**WEST SUSSEX COUNTY COUNCIL
STRATEGIC PLANNING CONSULTATION**

**SUBJECT: AL/26/14/PL - Change of use from 5 no. tourist units to 5No. residential units
(C3 Dwelling).**

**Easter Cottage, Norton Dairy, Cart Barn East Barn, Old Dairy Lane/Norton
Lane, Aldingbourne, West Sussex, PO20 3AF**

SITE PLAN 1:200

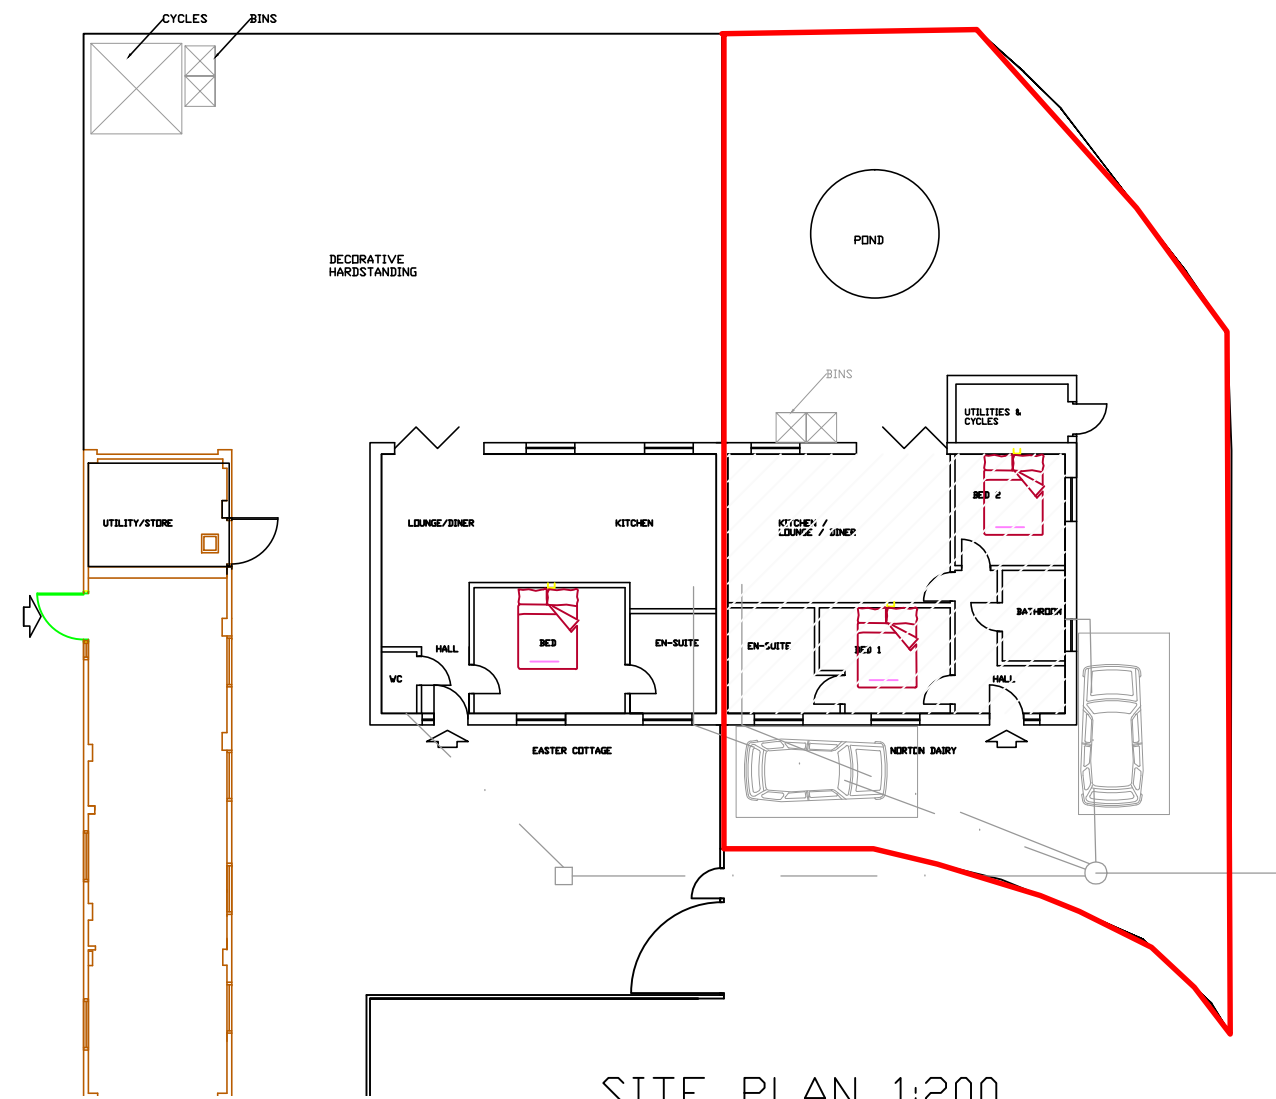
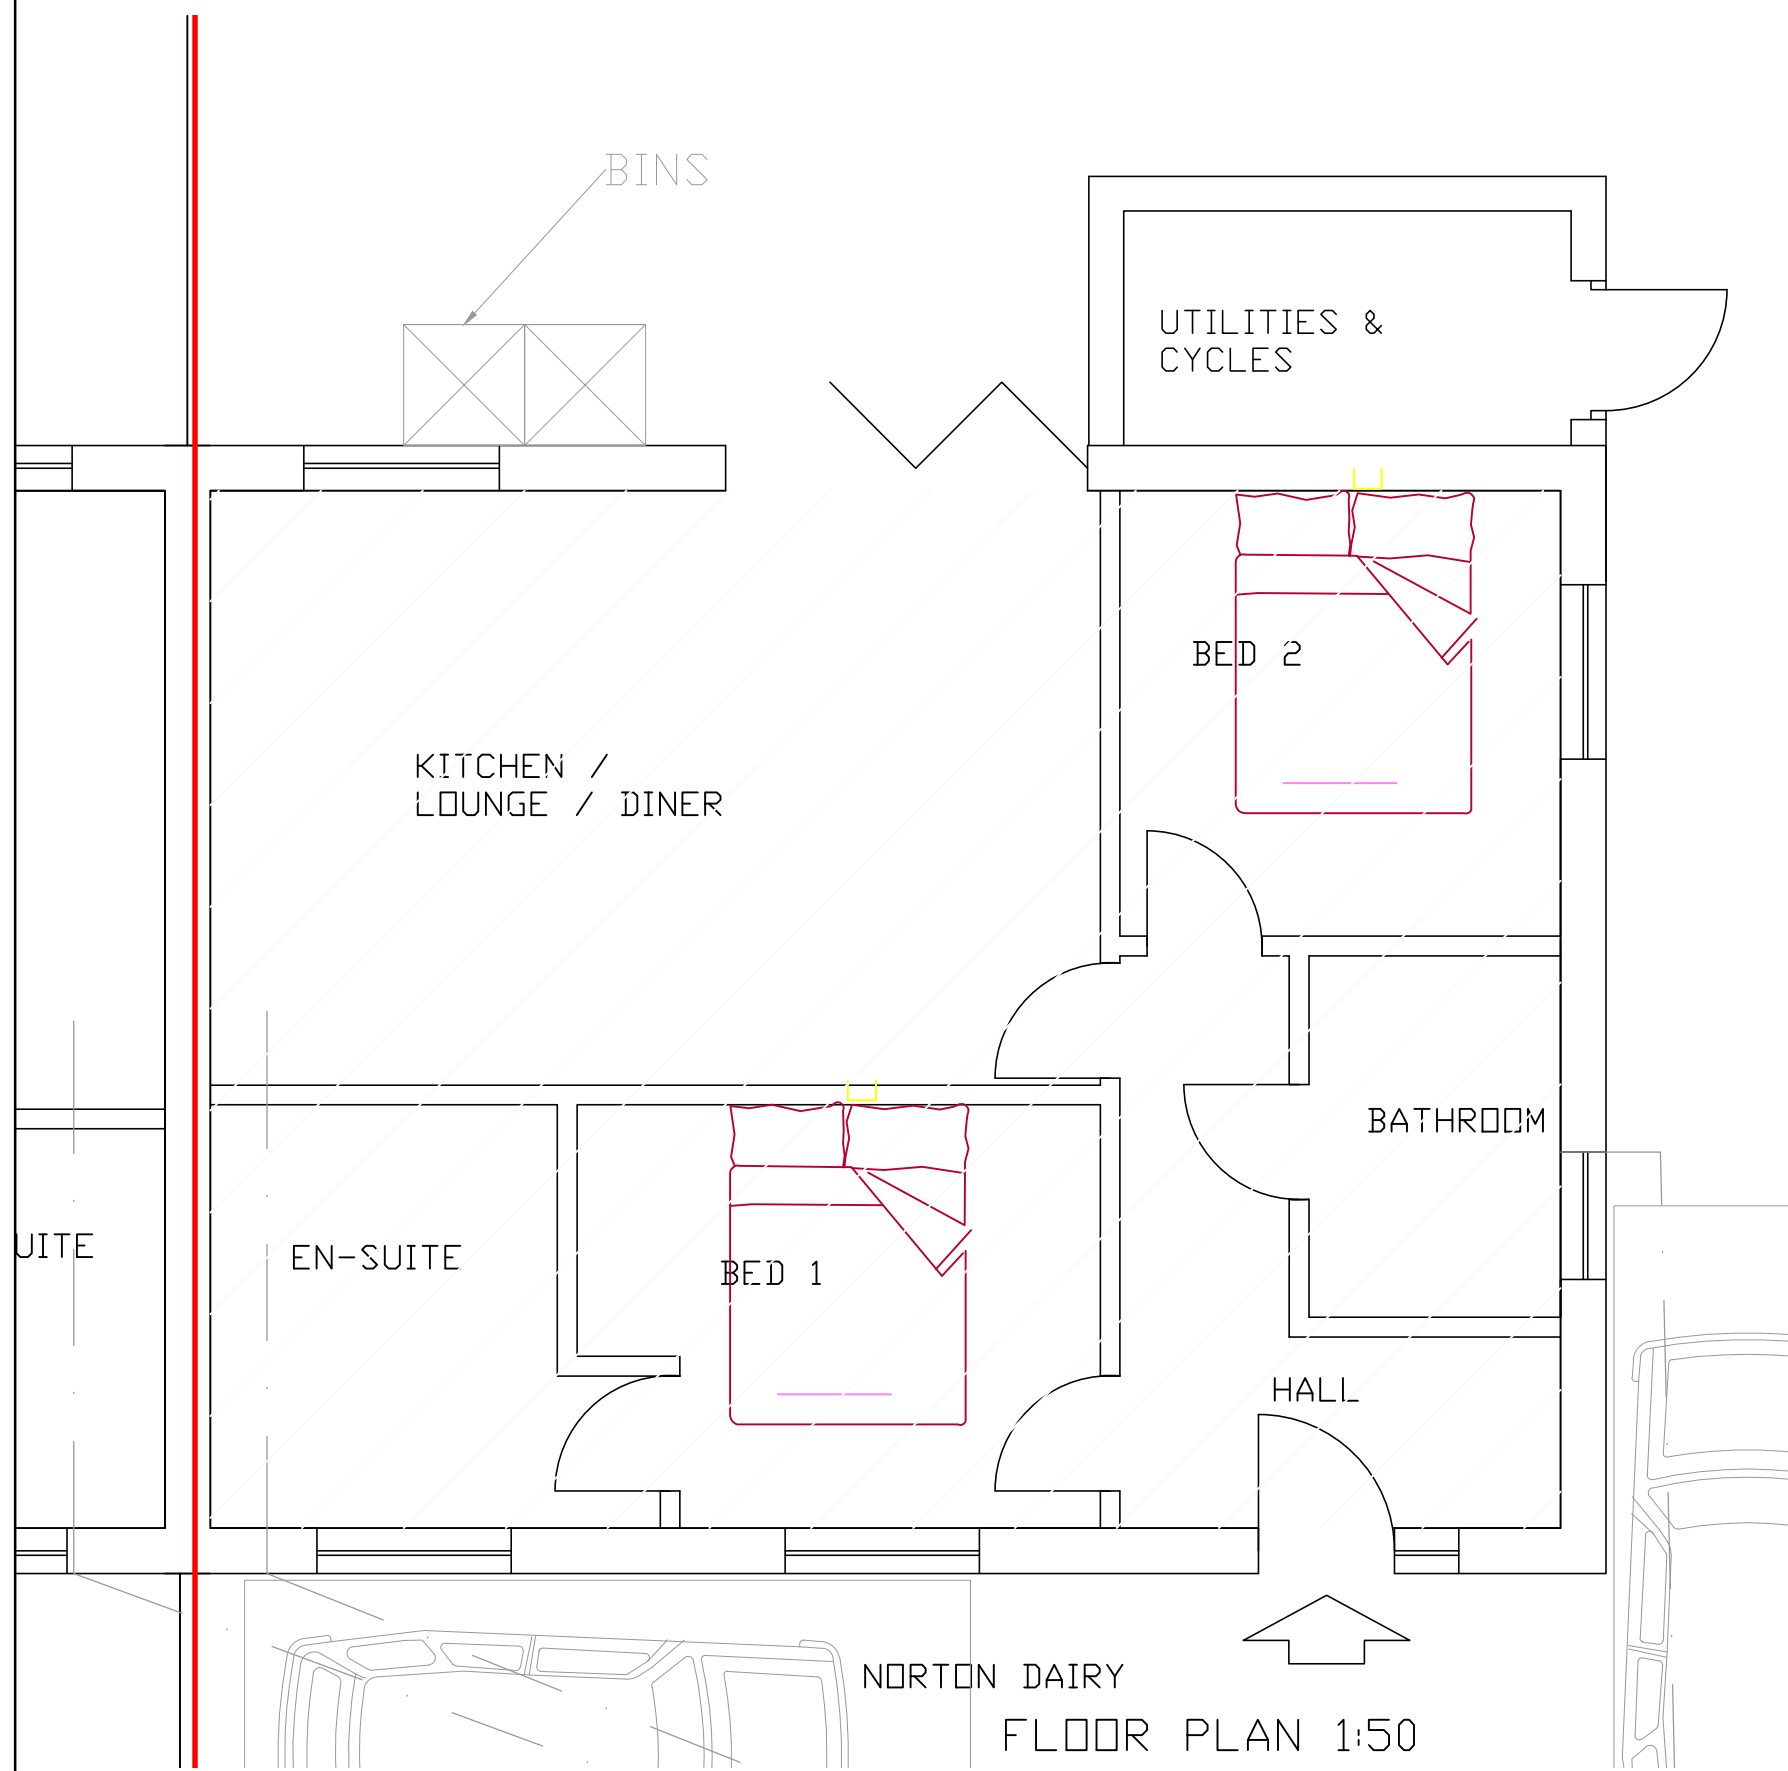
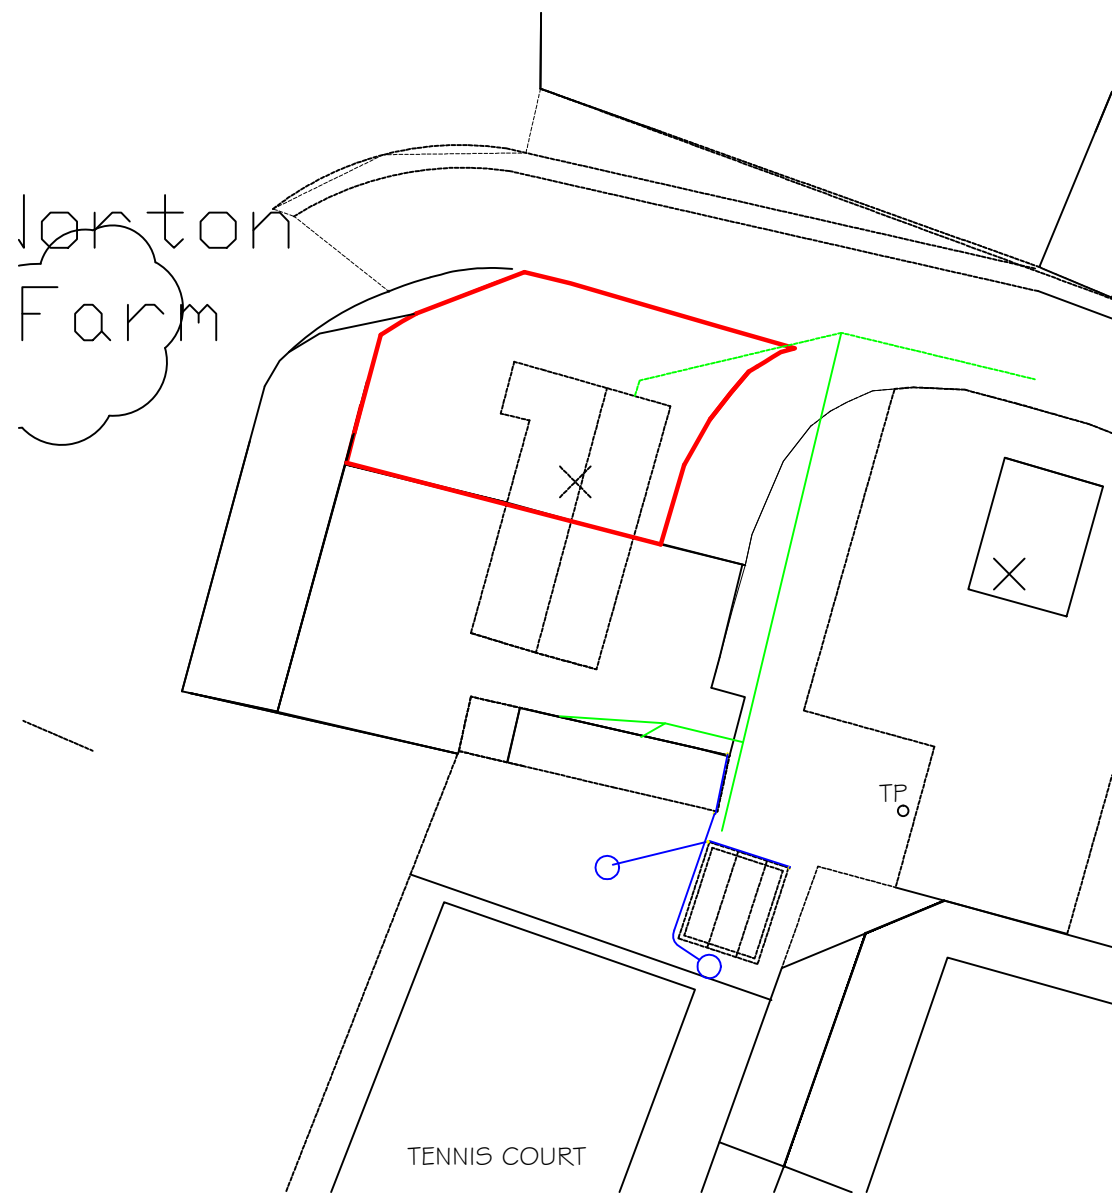
The plans and drawings provided by the applicant indicate there will be car parking and cycle storage areas allocated. The plans submitted show 9 spaces although no indication has been given to the location of the visitor parking. A parking layout plan including the location of visitor parking should be submitted to the LPA indicating where the visitor spaces will be located in accordance with WSCC car parking standards for 9 allocated spaces and 2 visitor spaces.

- 1) Visibility splays achieved set back 2.4m from the carriageway edge
- 2) Car parking allocation plan including visitor spaces
- 3) Turning area provided for cars and removal lorries
- 4) Refuse collection arrangements
